3 SIDEWALK RAMP DETECTABLE WARNING TILE AND APEX RAMP
NOT TO SCALE

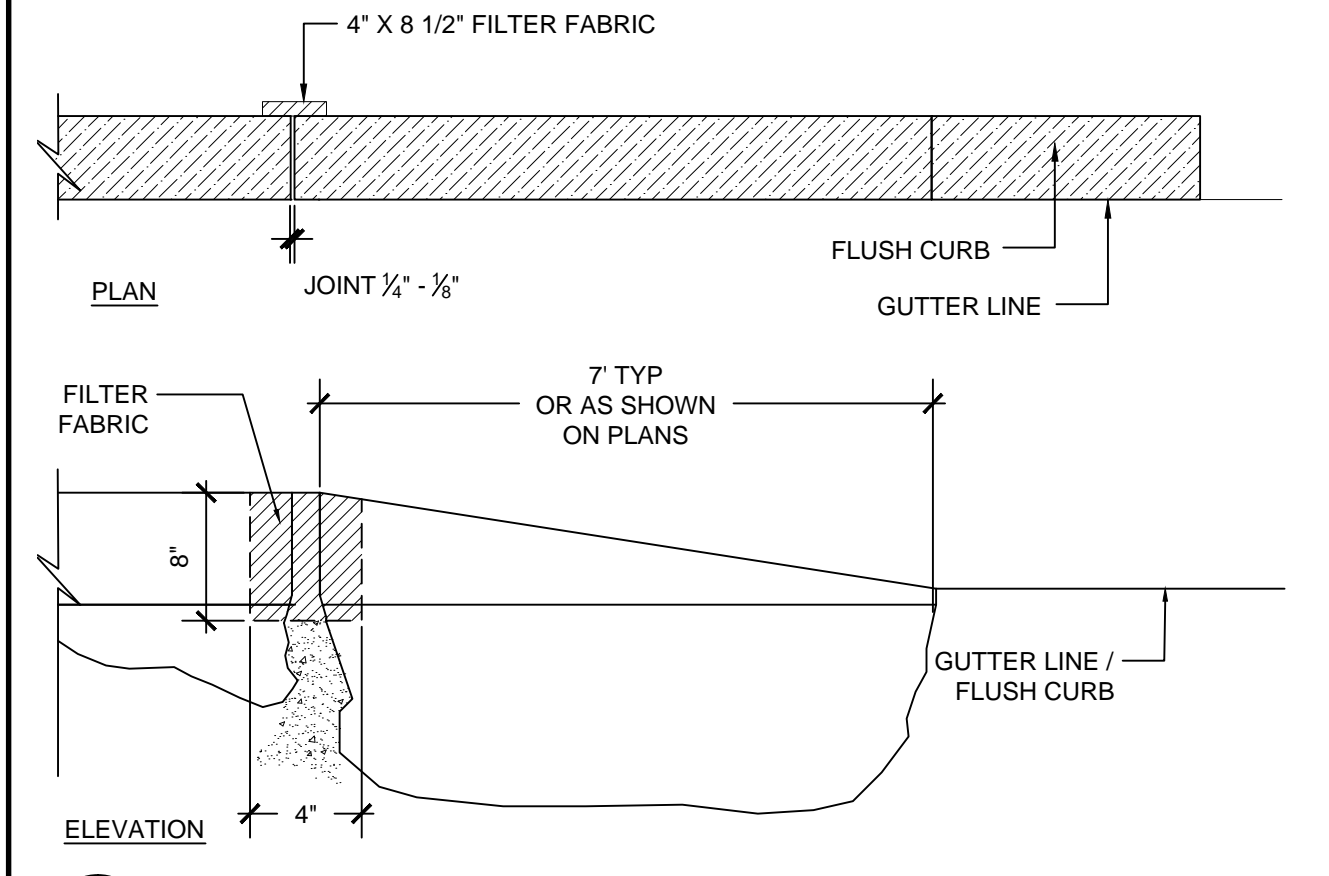
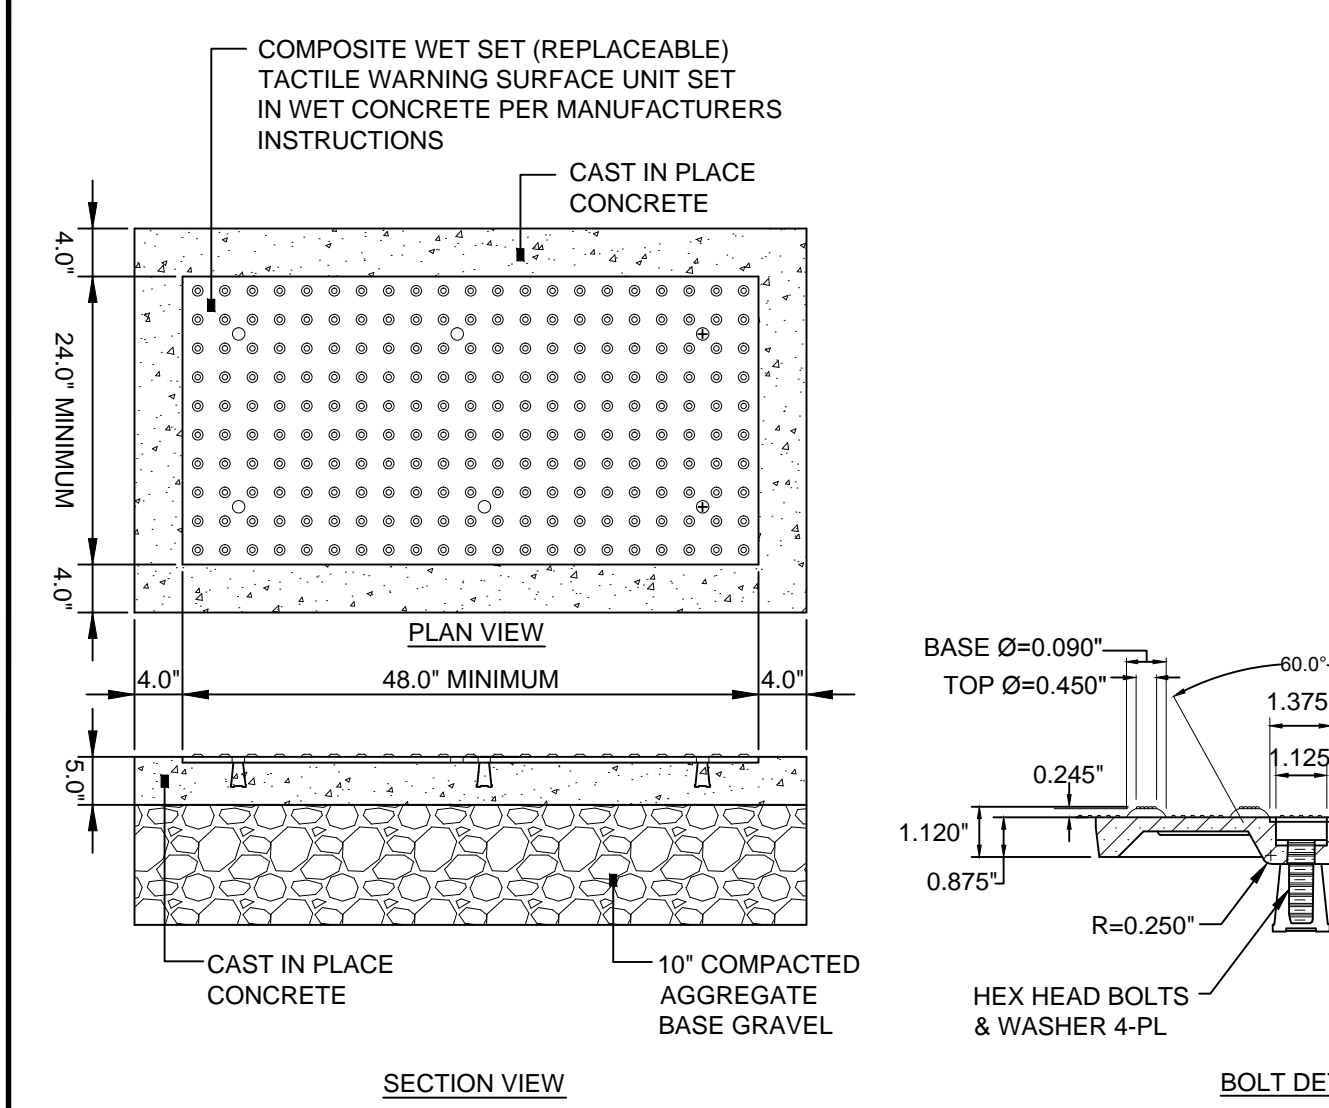
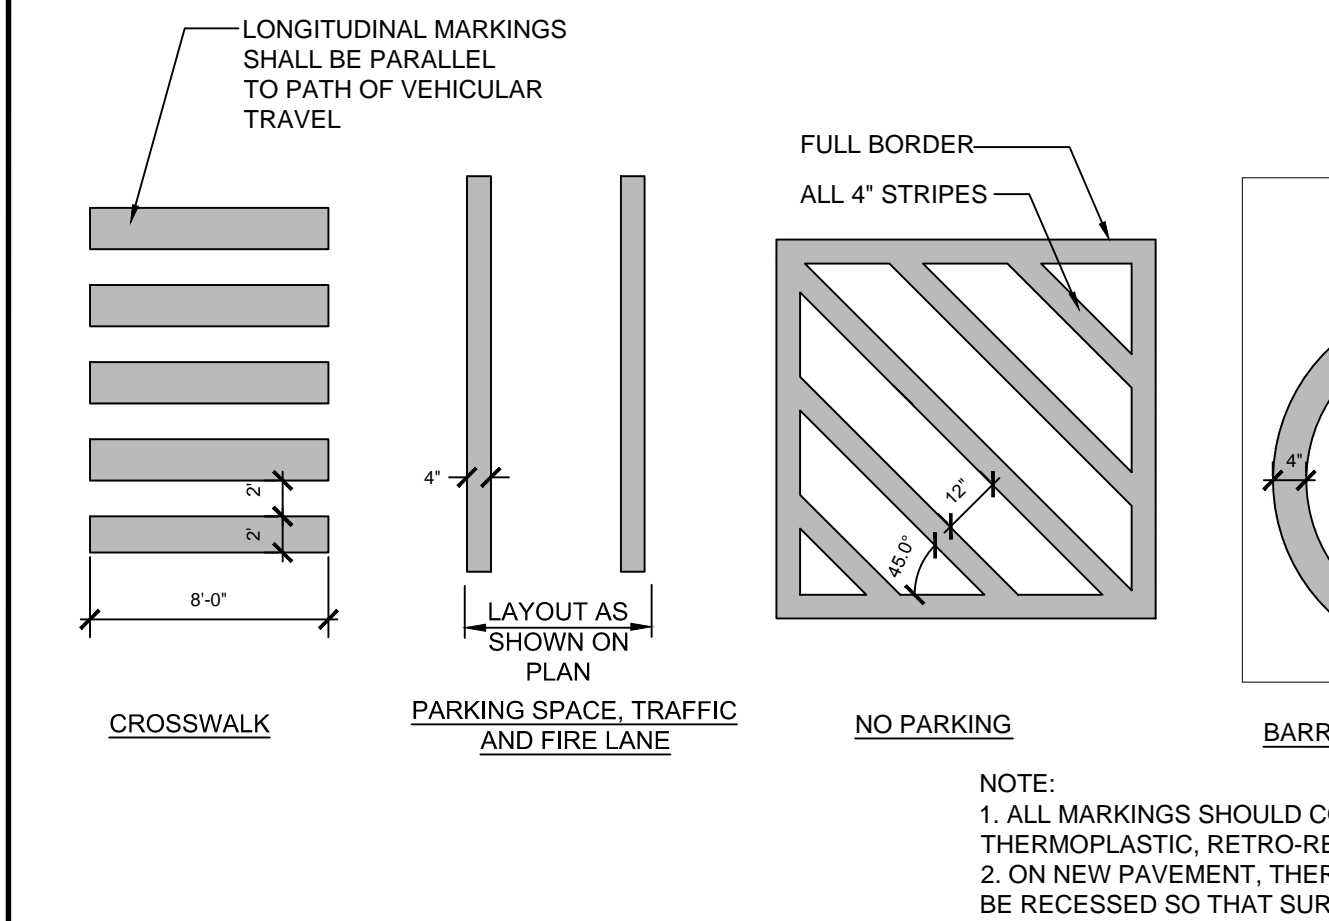
2. The applicant shall ~~submit~~have submitted final details for the reconstruction of the ramp on the south side of Hersey Street to meet ADA requirements~~for review and approval.~~ Said details shall have been reviewed and approved by the Department of Public Works; Said reconstruction shall be completed, approved, and accepted by the Department of Public Works prior to issuance of a Certificate of Occupancy.

2. The applicant shall have submitted final details for the reconstruction of the ramp on the south side of Hersey Street to meet ADA requirements. Said details shall have been reviewed and approved by the Department of Public Works; Said reconstruction shall be completed, approved, and accepted by the Department of Public Works prior to issuance of a Certificate of Occupancy.
